*COMMENTS ON ANY FURTHER
INFORMATION / SUBMISSIONS
RECEIVED BY DEADLINE 5*

CowfoldvRampion and Cowfold Residents
CowfoldvRampion@gmail.com

Version 2 – August 2024

Oakendene substation indicative landscape plan 2285-WSPE-EX-ON-FG-OL-7754:

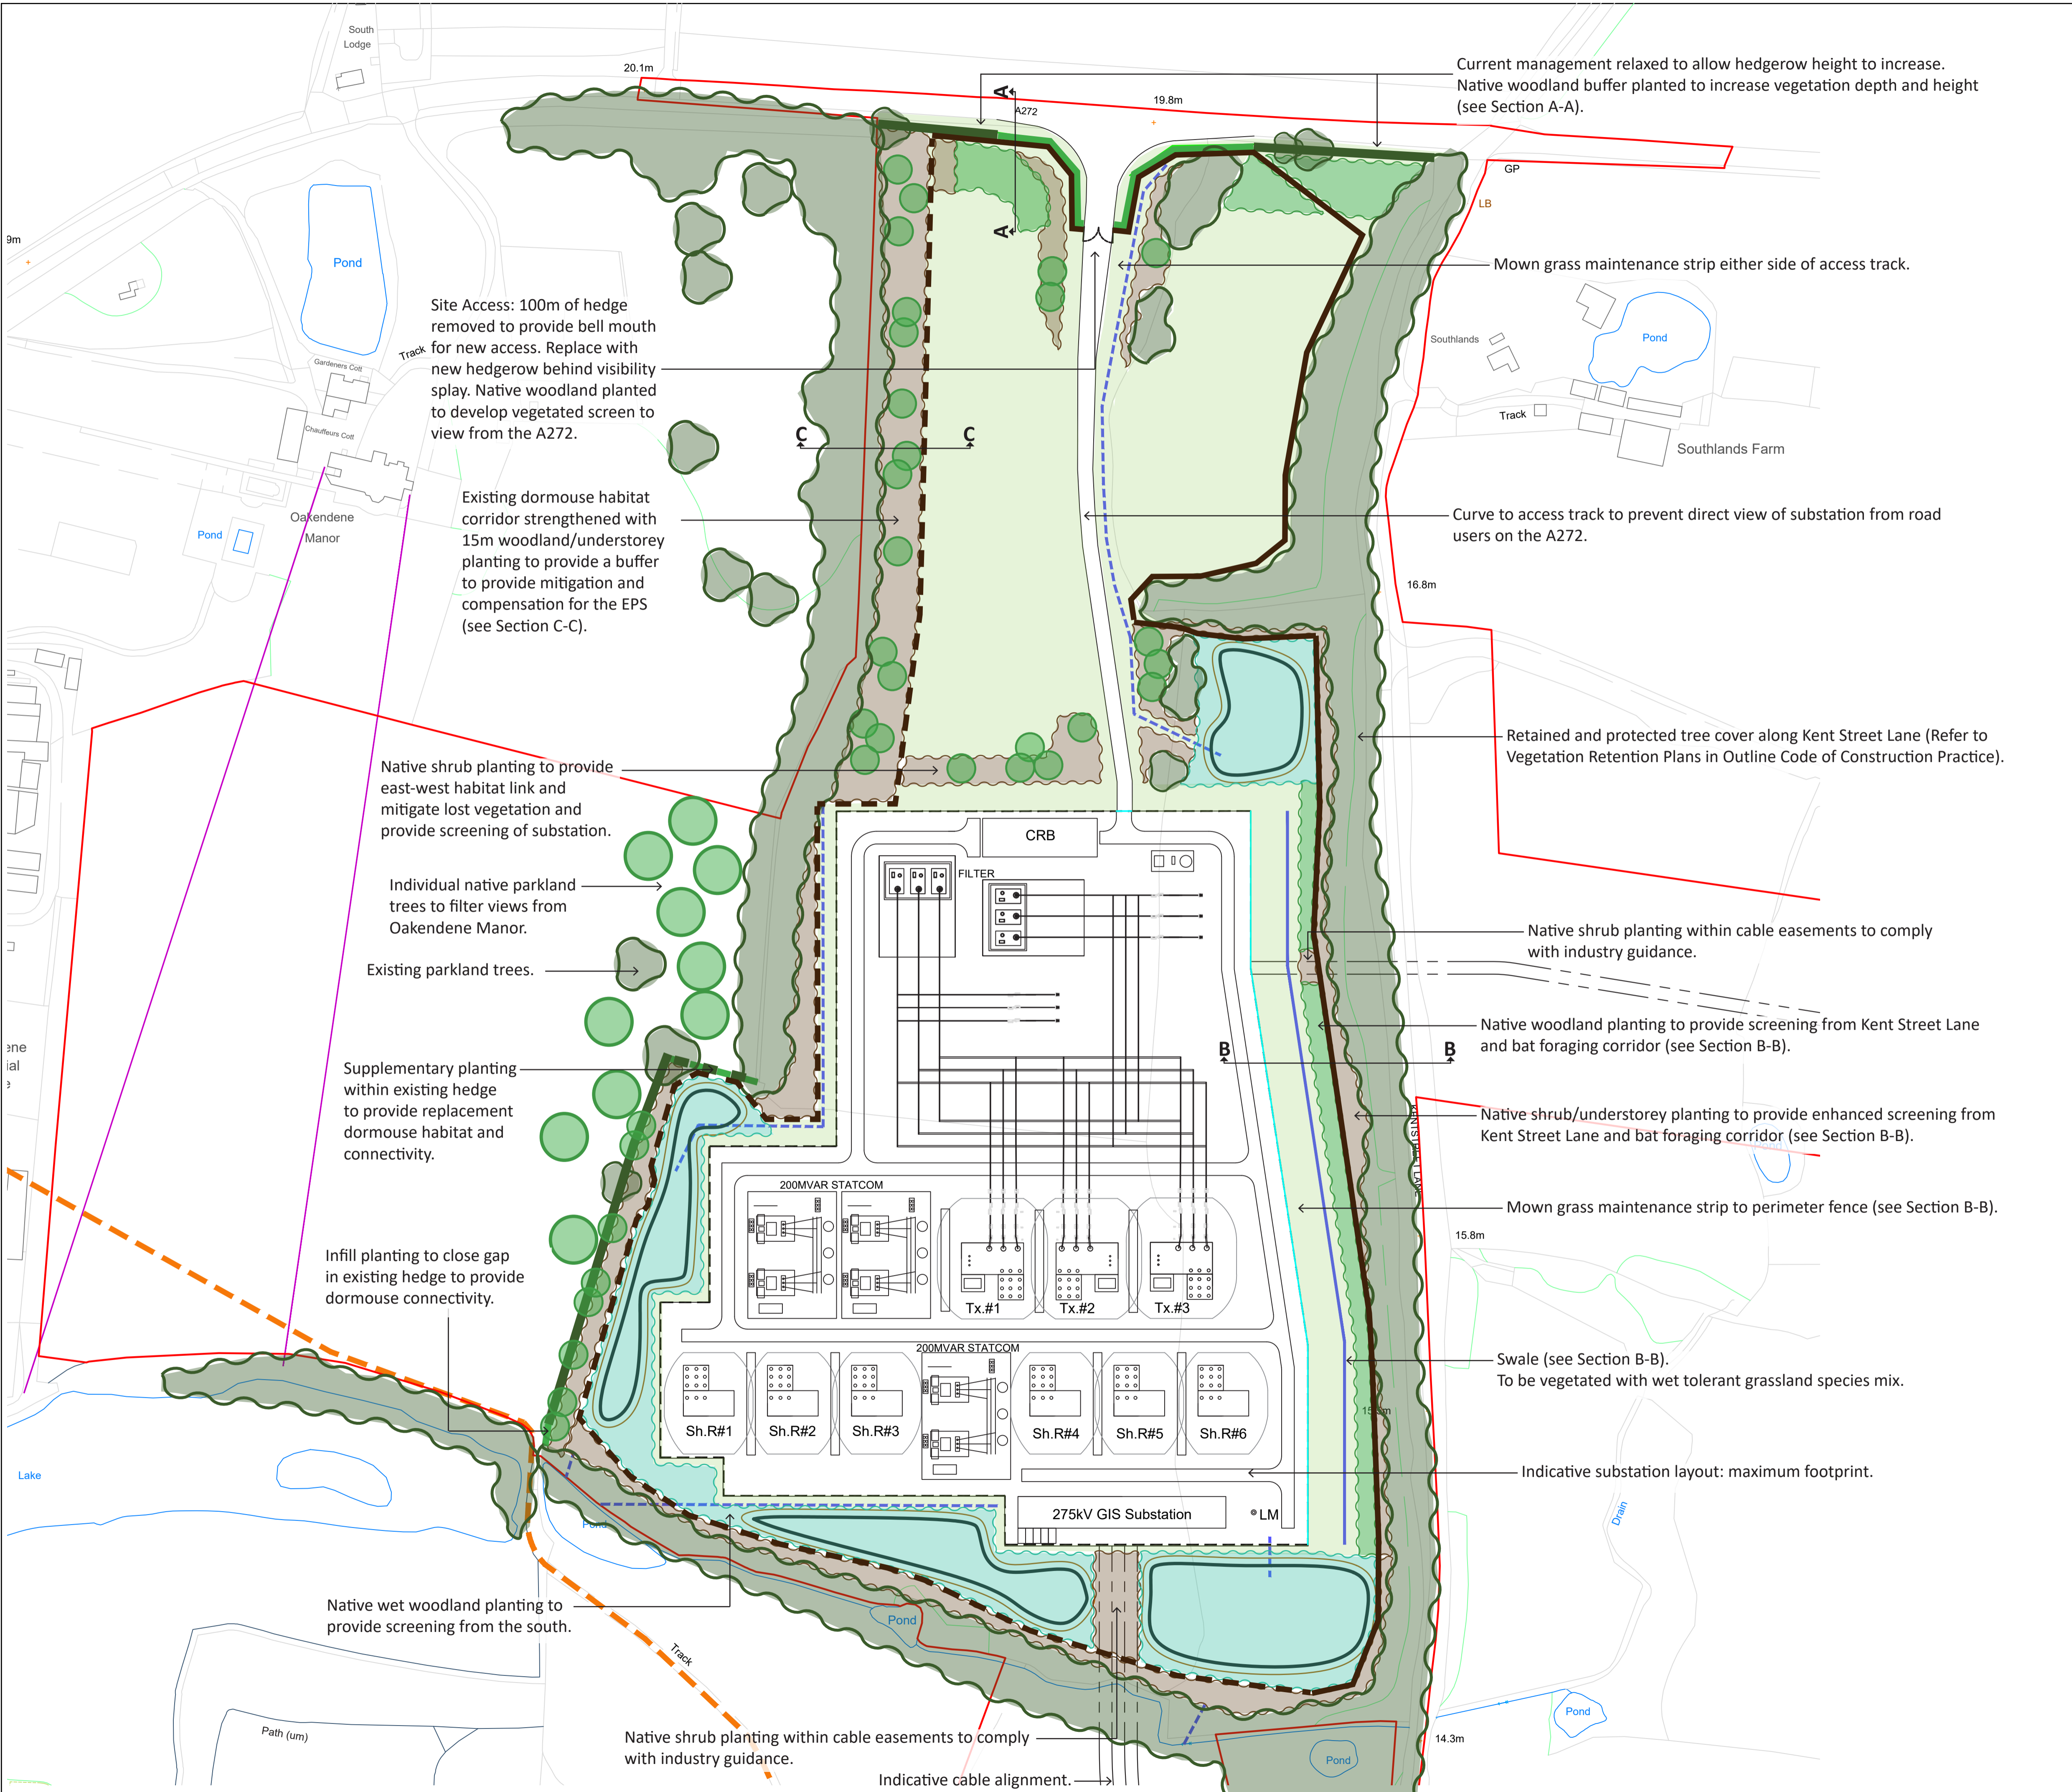
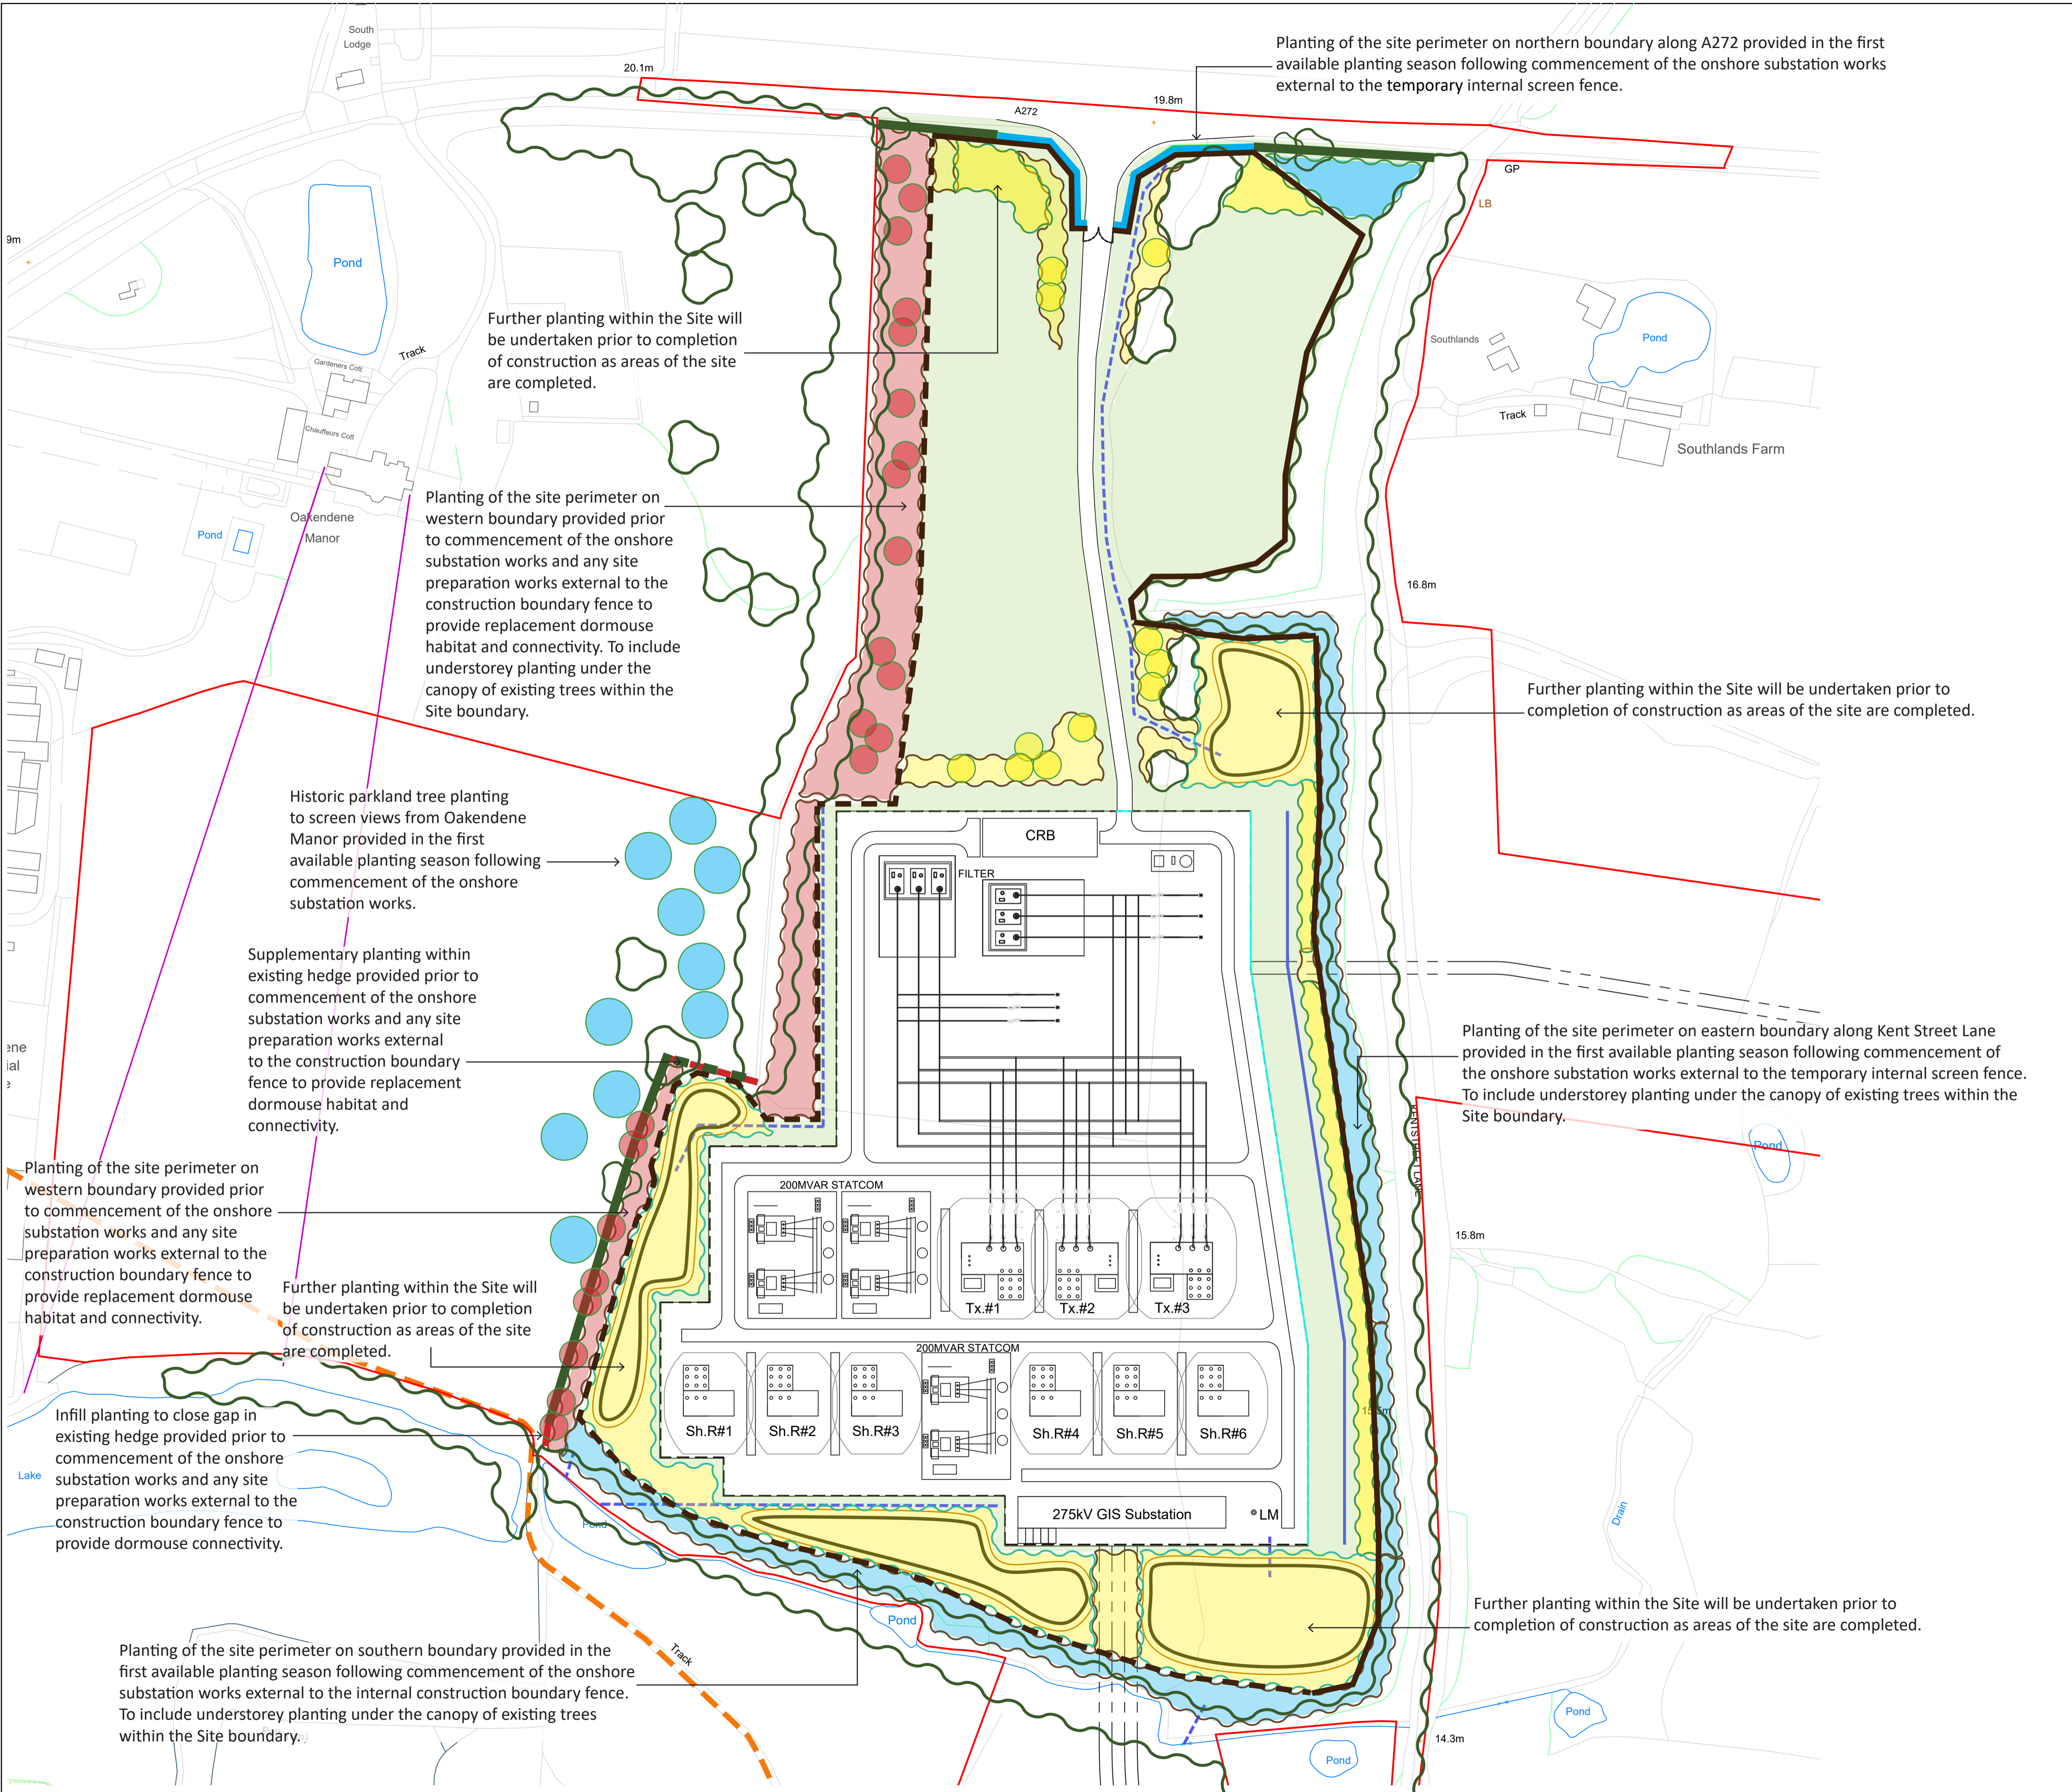
The small area described as "Vegetation temporarily lost to improve the A272 / Kent Street junction during construction will be reinstated." Is far smaller than on the Kent Street swept path diagrams and gives a misleading impression. Also, the hedge H520 is partially lost to create the turning arc.

The grey area running down the eastern border of the site is described as "Existing woodland/vegetation **retained**". However, this is also described in the TPO and hedgerow retention plan (REP5-003) **as H610 and H505 for removal**. This is also dramatically enlarged on the plan, again to give a false impression of how effective it might be, as on the plan it actually crosses the lane and over into the verge on the opposite side!

The indicative planting scheme is still showing "First available planting season following commencement of the onshore substation works" for the turning arc at the north end of Kent Street, and does not show the impact of the Kent Street visibility splay on the hedgerows
